CITY OF ALBUQUERQUE

December 30, 2011

Re: Fire Station No. 2, Grading and Drainage Plan
Engineer's Stamp dated 12-19-11 (L15/D060)

DRAWING TITLE: GRADING AND DRAINAGE PLAN

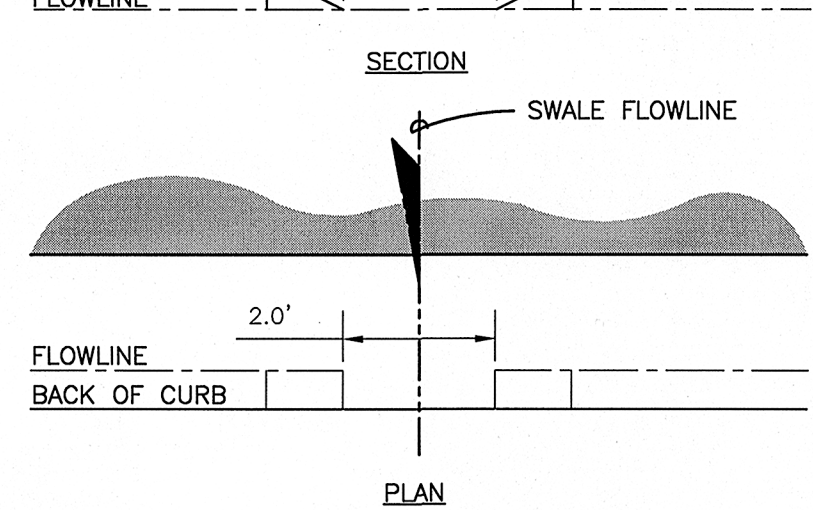
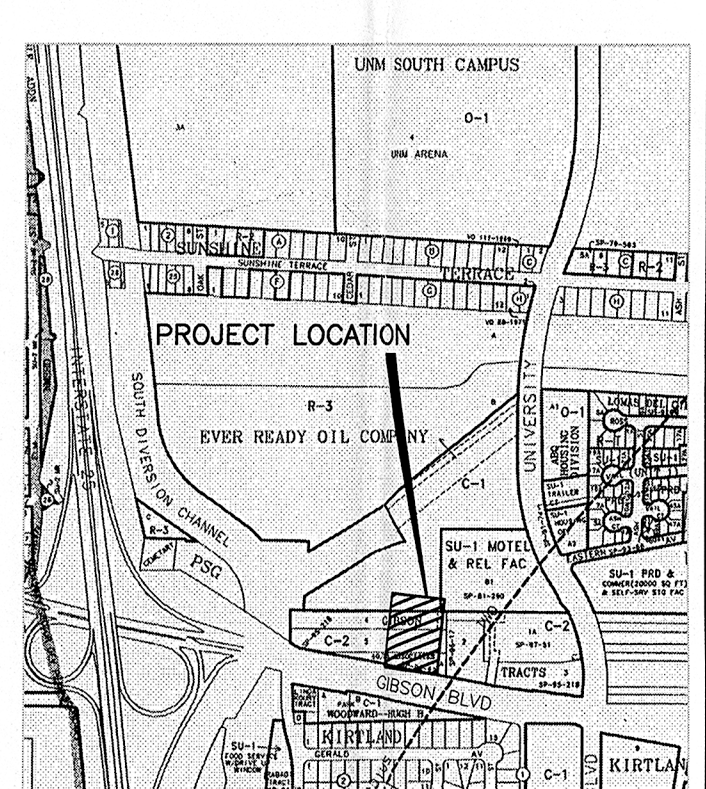
- The retention pond and swale leading to it, as part of the Site Plan approval, is required to be on this Grading Plan. If the facility in the easement is constructed during the construction of this site, a new Grading Plan can be submitted showing the facility in the easement and therefore a pond would not be necessary.

- Provide flow and volume calculations, a project narrative and basins.
- Show the flows leaving the site as was shown in the submittal for Site Plan approval.

- Provide widths of sidewalk culverts in the ROW, specify to be built per COA STD DWG 2236 and provide SO 19 Notes.
- Provide spot elevations and a build note for the curb cuts.

- Provide a detail for the swales leading to the sidewalk culverts.
- Does the access drive transition to inverted crown at the west end? It is not clear how runoff will enter the swale. In addition, it appears there is curbing proposed at the west end.

- Provide direction of roof flows.
- Why is the BW grade at the north end of the retaining wall 5047.0, when there is a proposed 5054 contour in this location?

- Additional spot elevations should be provided; in the corners of the parking areas, in the dumpster enclosure, upstream of sidewalk culverts, flow line in Alumni Dr. at proposed drive entrances.
